ENG-CDR21010-R5-CDs-Vollmer North.pdf Markup Summary

VOLLMER NORTH PROFILE (3)
STA 57+00.00 TO 67+50.00

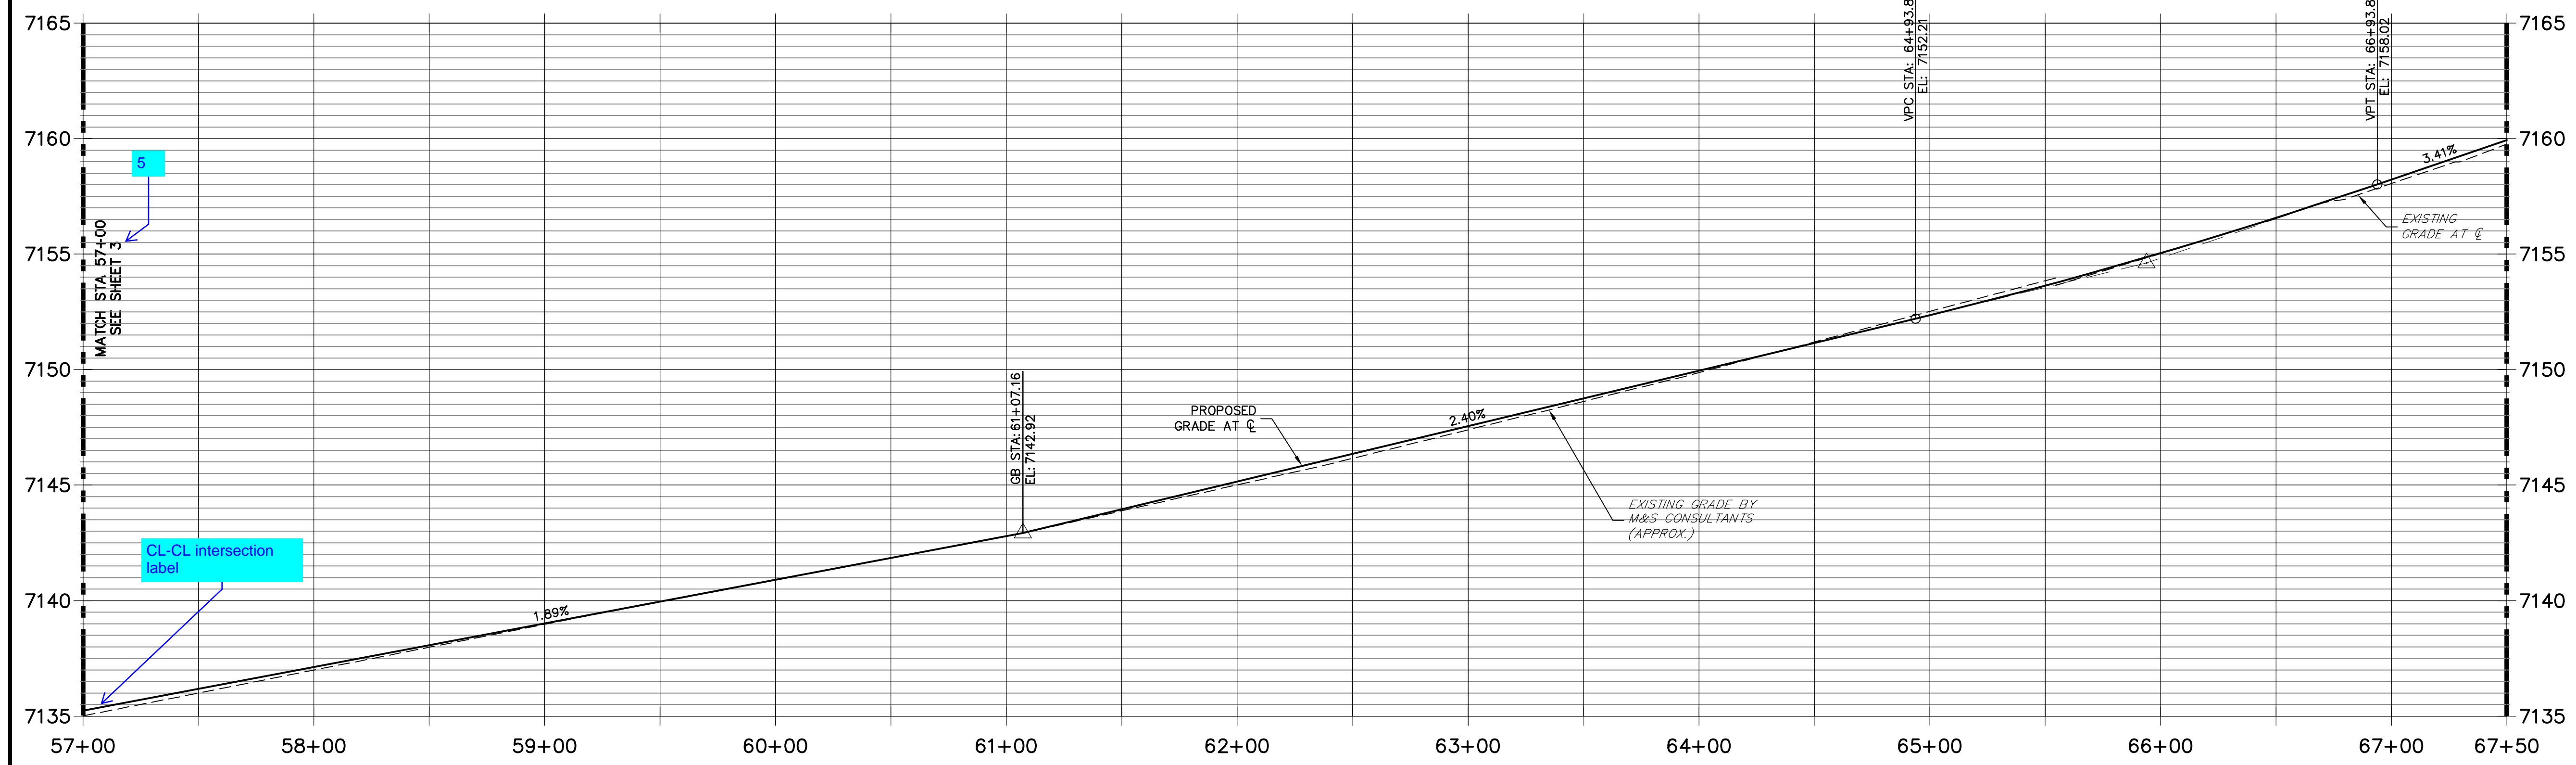
Min K value is 96 for Arterial Road w/45 mph posted speed
